Arun District Council
Arun Civic Centre
Maltravers Road
Littlehampton
West Sussex BN17 5LF
Planning & Building Control General Enquiries
Tel: (01903) 737756 Fax: (01903) 730442
Dx: 57406 Littlehampton
Minicom: 01903 732765
e-mail: planning@arun.gov.uk
website: www.arun.gov.uk/planning

Application No: R/91/20/PL
Site Address: 6 Manor Road Rustington BN16 3QT
Description of works: Demolition of existing garage & store on existing dwelling & erection of 1 No detached bungalow to rear.

Thank you for your internet representation made on 23rd June 2020 which has been recorded as an objection with the comments as follows:

BLOCK PLAN: 6 MANOR ROAD, RUSTINGTON.

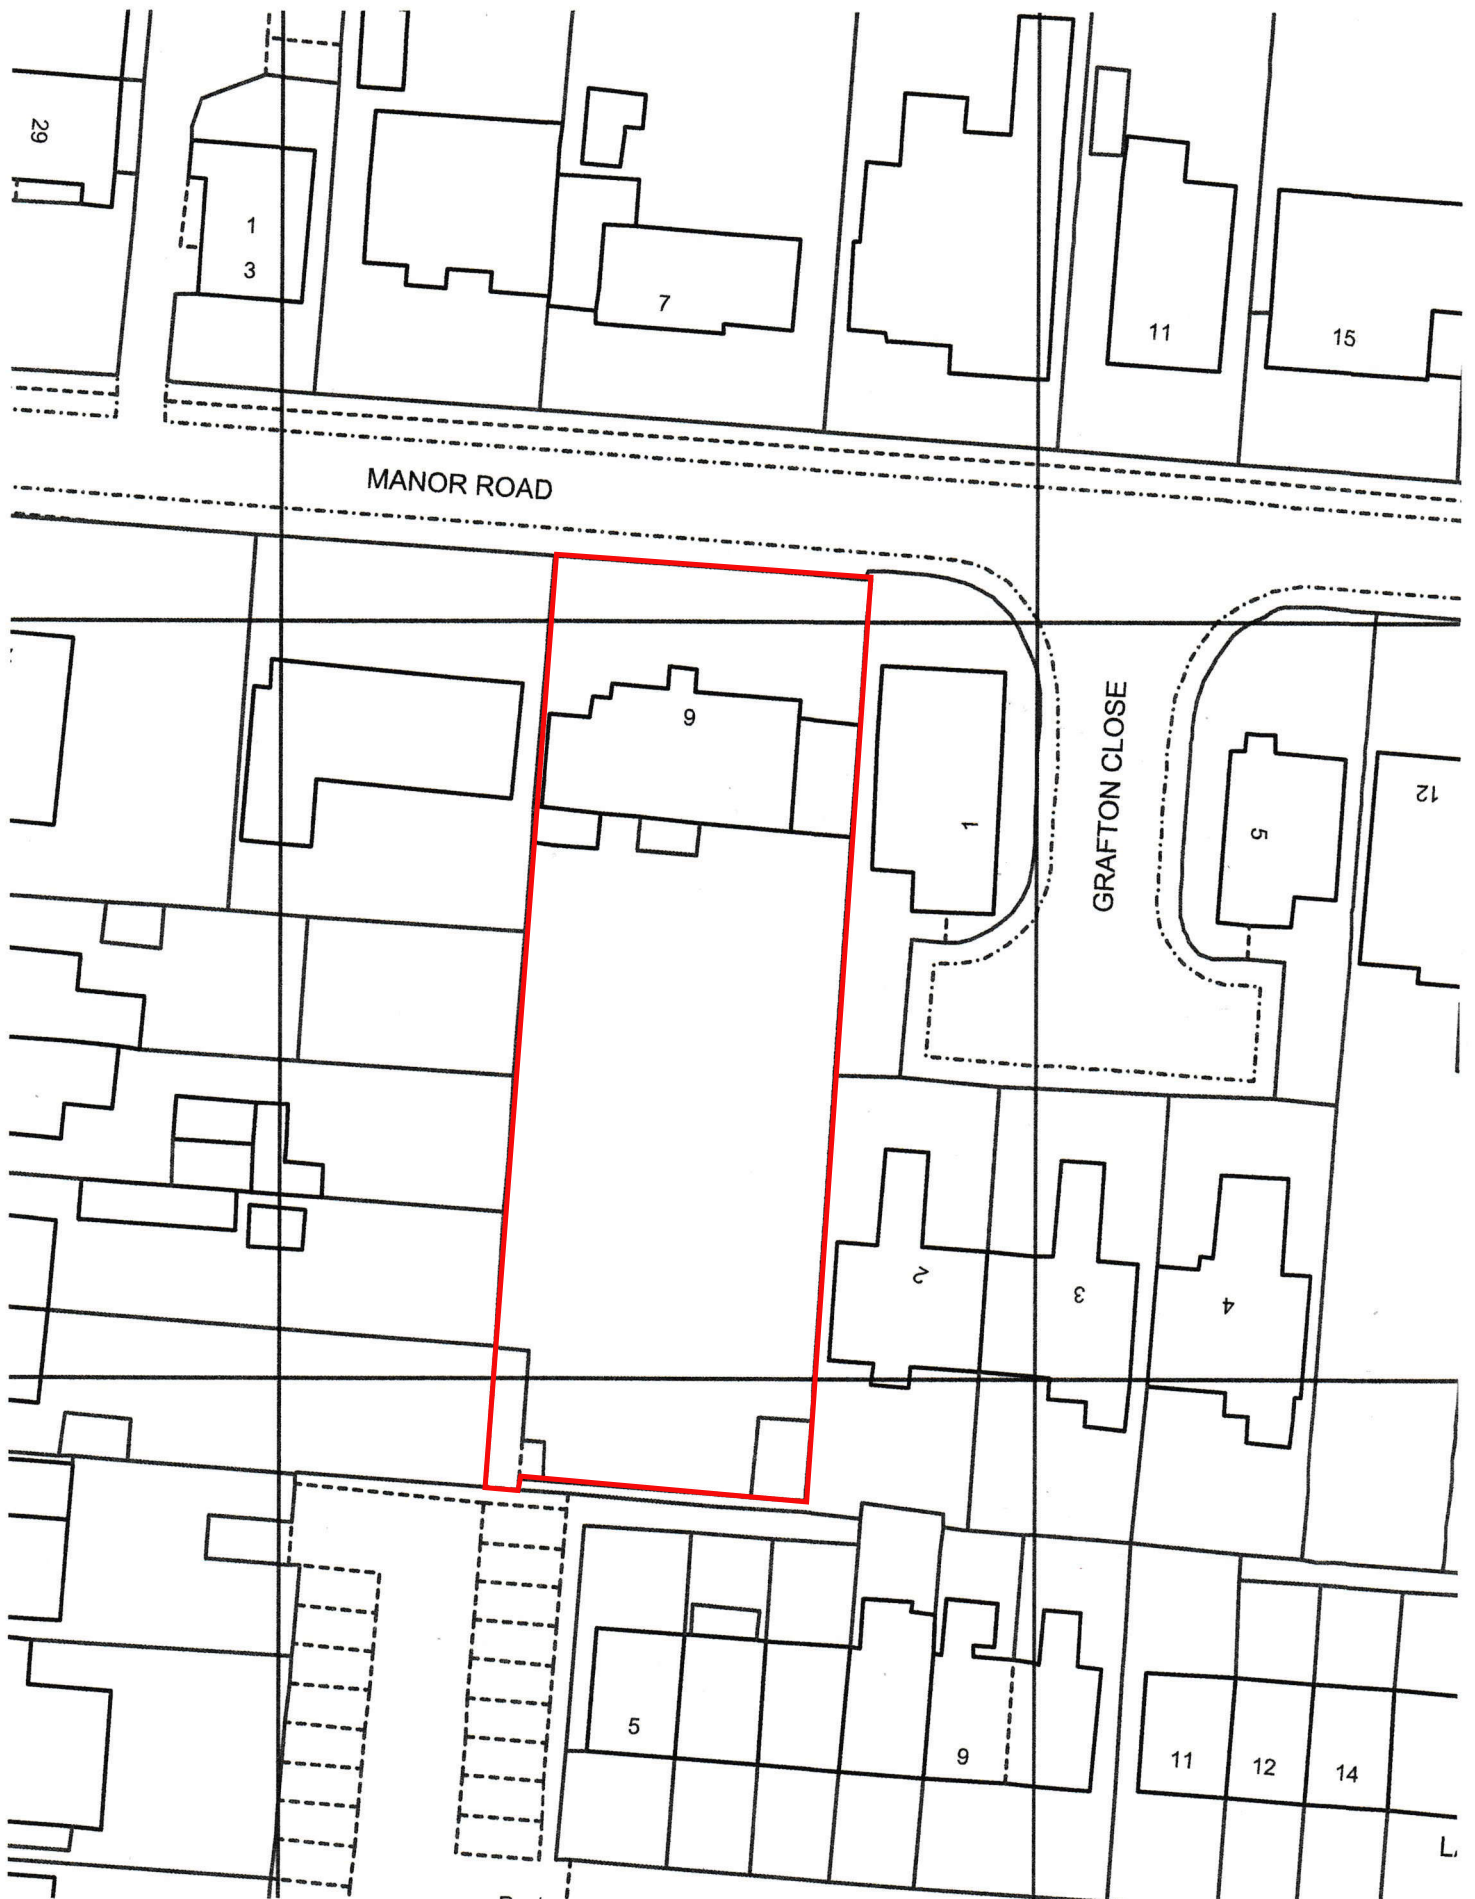
The Proposed Site Plan shows '1.8m high acoustic fencing with option for 'Green Living Fence' installed in front for added acoustic buffer and verdancy.' It has been agreed (6.17) in the Planning Support Statement that acoustic fencing (6.15) 'will be secured by way of proposed condition 5', however, this only requires that (6.16) 'No development above damp proof course (DPC) level shall take place until details of acoustic fencing to the side boundaries of the access have been submitted to and approved by the Local Planning Authority and the new dwelling shall not be occupied until the approved acoustic fencing has been erected' To ensure that (RNP 4.12) 'Development not impact on surrounding properties .. and alleviate possible noise issues to existing neighbouring properties' the acoustic fencing should be required to be in place before building work commences, not just before the new dwelling can be occupied.

The addition of a 'Green Living Fence' should be made a Condition in addition to the acoustic fencing in order to increase the 'acoustic buffer and verdancy' and to replace the shrubs and plants that were ripped out when the garden was cleared in advance of the planning application being submitted.

We are also very concerned about the possible noise, pollution and vibration to the foundations of our property by the heavy lorries delivering building supplies directly to the construction site, using the new driveway created between our property and no.6, when the existing garage is demolished. What is the weight limit or restrictions applicable to lorries using residential driveways?
